Town & Country Planning Act 1990 (as amended) s211 Notice

Prior Notification of Work to Tree(s) in a Conservation Area

Development: 1no. Leyland Cypress tree (T1) to be felled.
1no. Group of mixed species (TG1) is to be cut back to the boundary line from base to upper extent where necessary.
1no. Group of mixed species (TG2) is to be cut back to the boundary line from base to upper extent where necessary.
Trees are within Angmering conservation area.

Location: Church Farm House Rectory Lane Angmering BN16 4JU

Tree Location plan

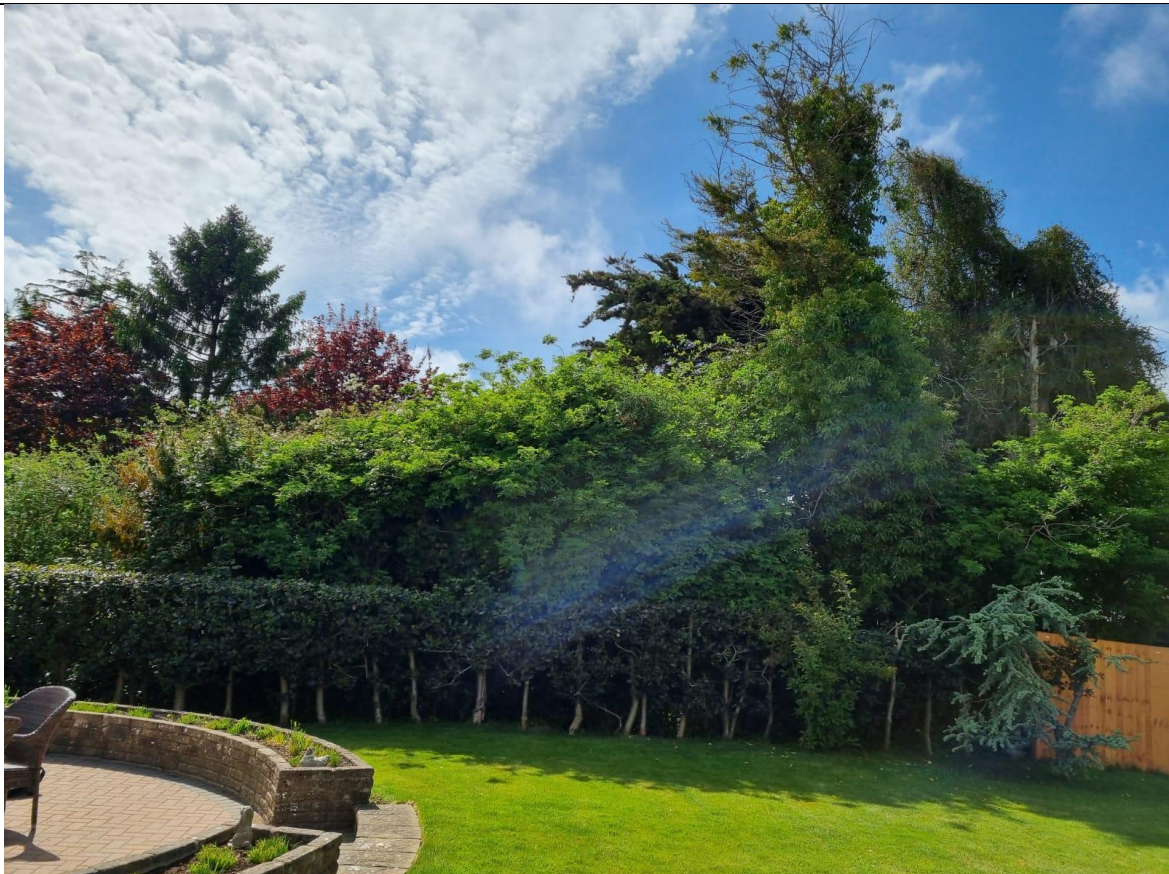
Please identify T1, TG1 and TG2 on the same sketch map, the current tree location plan does not identify T1 which you are proposing to fell.
